WEST SUSSEX COUNTY COUNCIL CONSULTATION

FROM: WSCC - Highways Authority

LOCATION: West Barn, Old Dairy Lane, Chichester ,PO20 3AF

SUBJECT: AL/70/20/PL

Proposed Site Plan

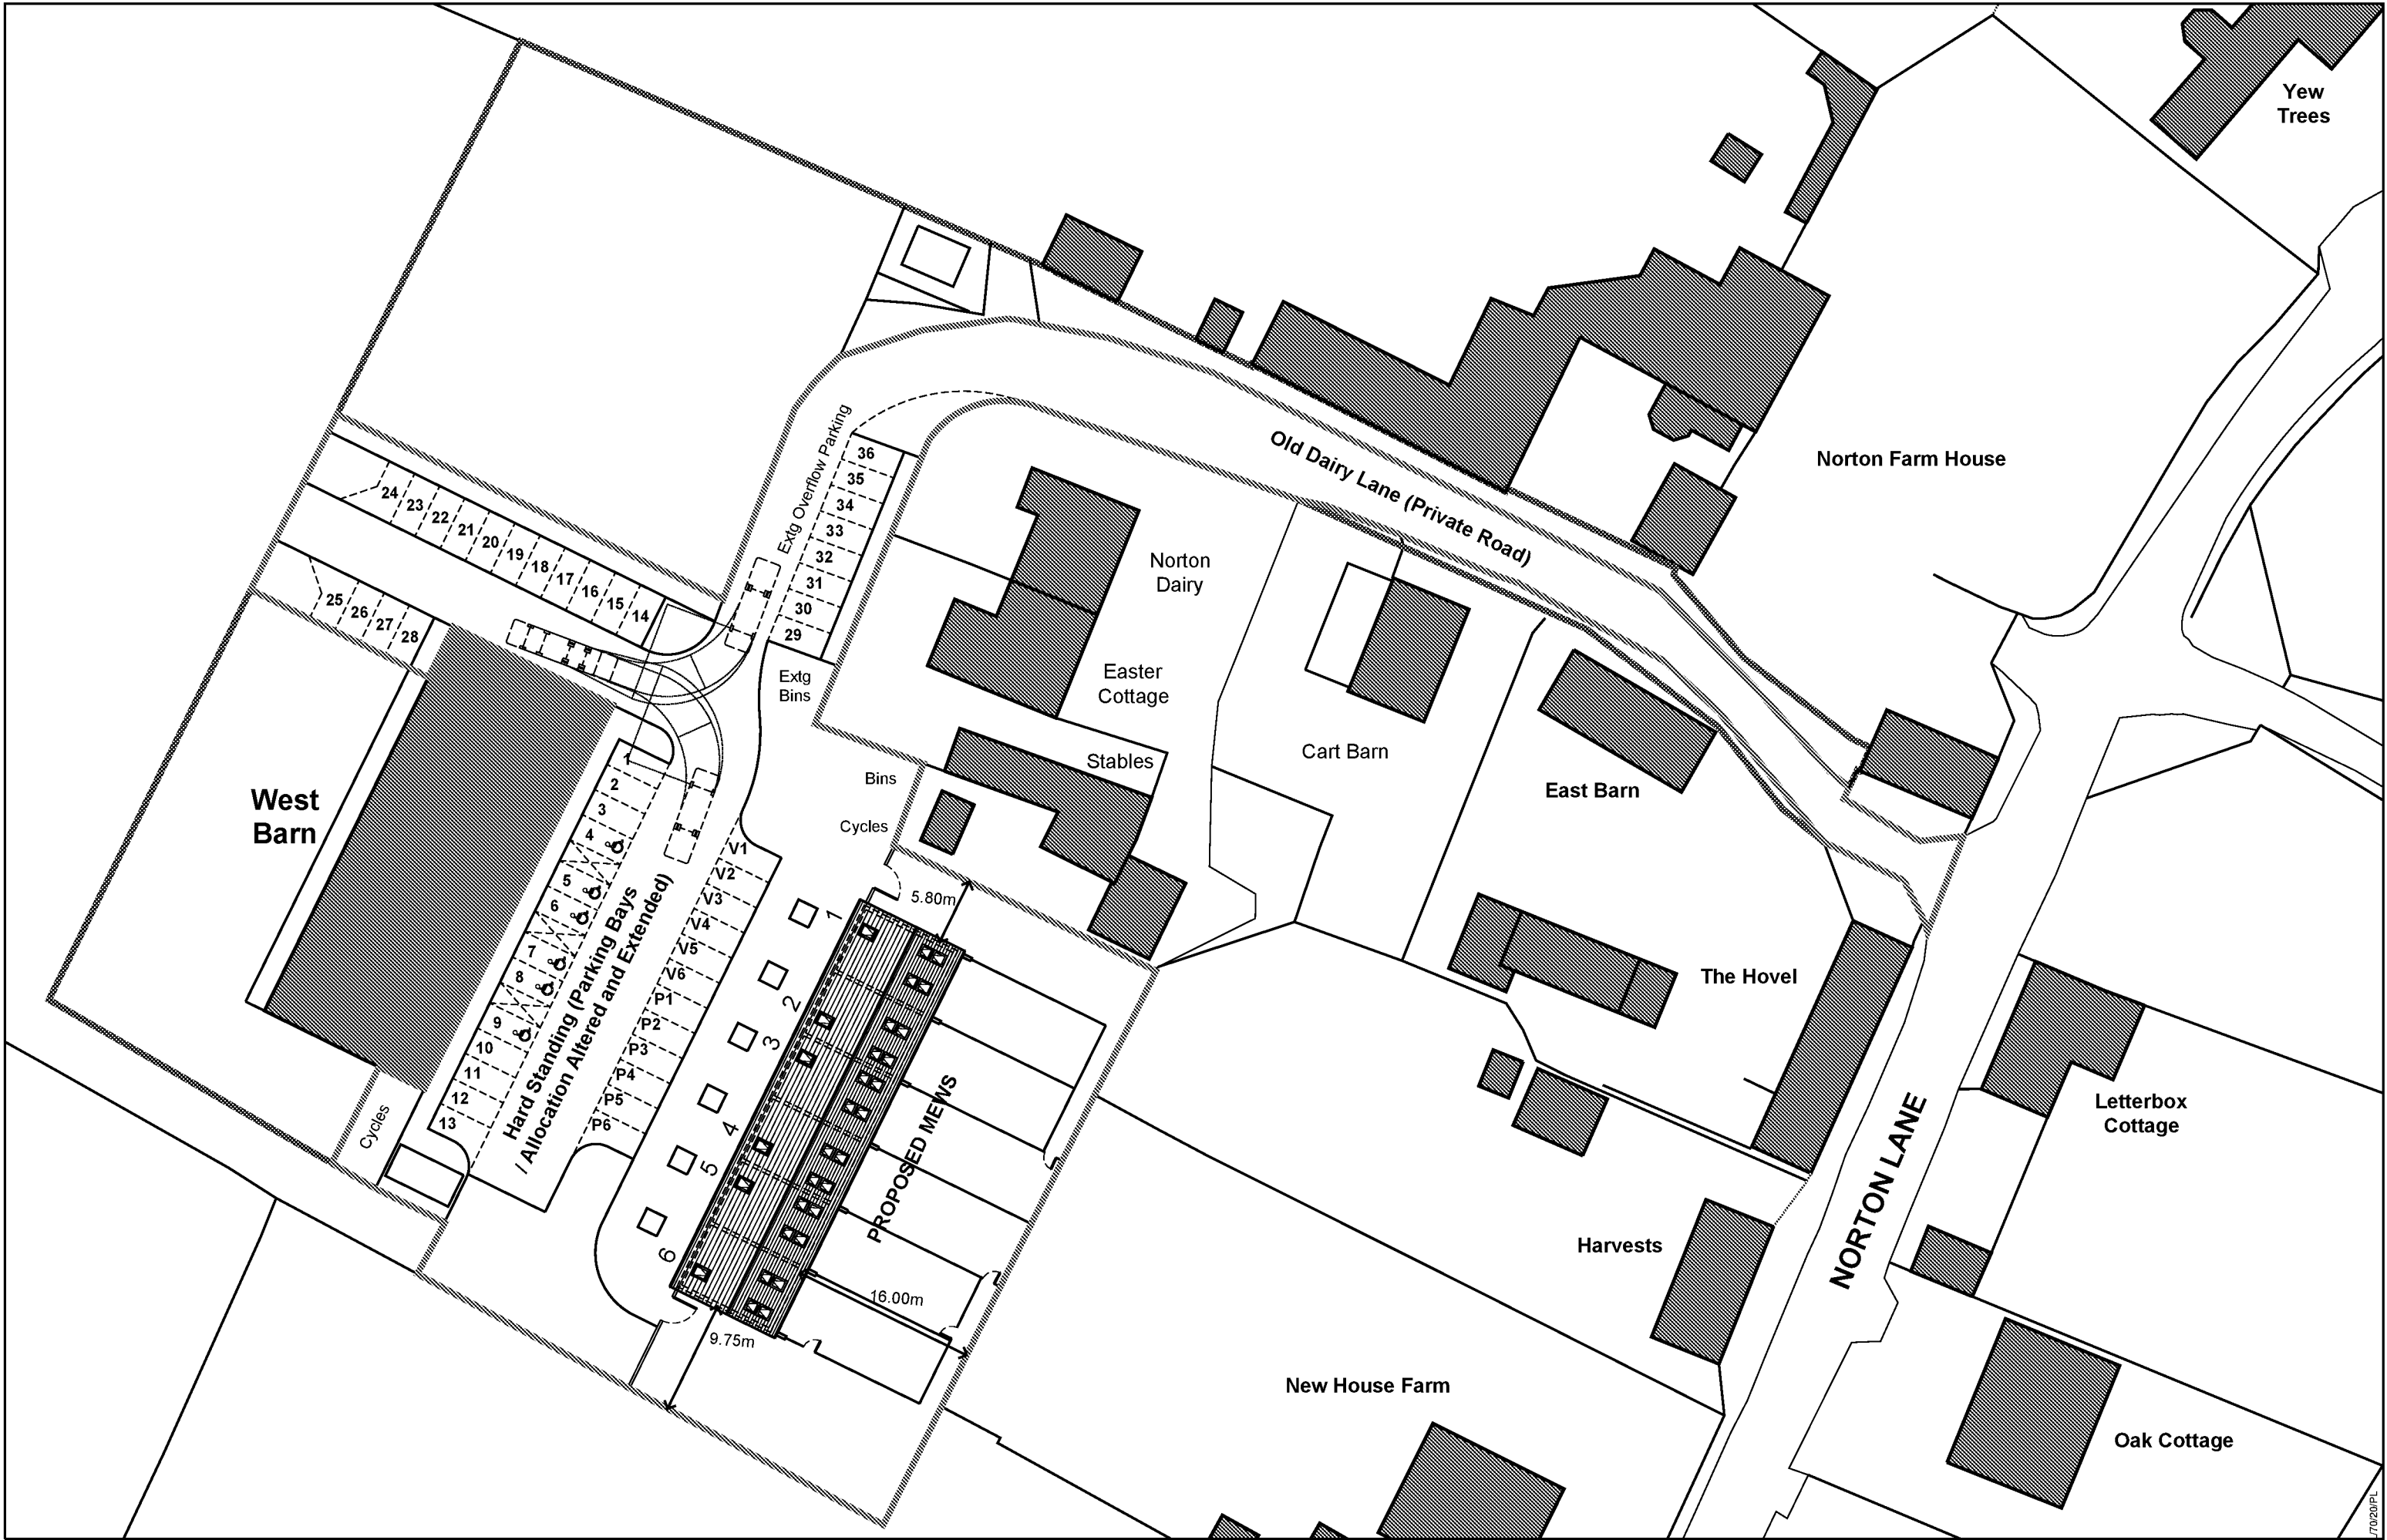
The site provides car and cycle parking in line with ADC SPD Jan 2020. This indicates 2 car parking spaces, and 1 cycle space per dwelling. This equates to a total of 12 car parking spaces and 6 cycle spaces. As part of the governments road to zero strategy ADC SPD asks for all new developments to provide 100% of its parking with EVC facilities. Servicing of the site will continue in line with the existing arrangements. Bin carry distances must be considered when designing bin stores and a turning head is provided to ensure a refuse lorry can enter turn and exit in forward gear.

Fire and rescue service should also be able to turn on site and exit in forward gear as reversing of a fire appliance is only undertaken up to 20m, and Old Dairy Lane is longer than this.

The LPA should check with the local fire service to ensure an appliance can get within 45m of each dwelling or alternative measures such as sprinkler systems will need to be considered.
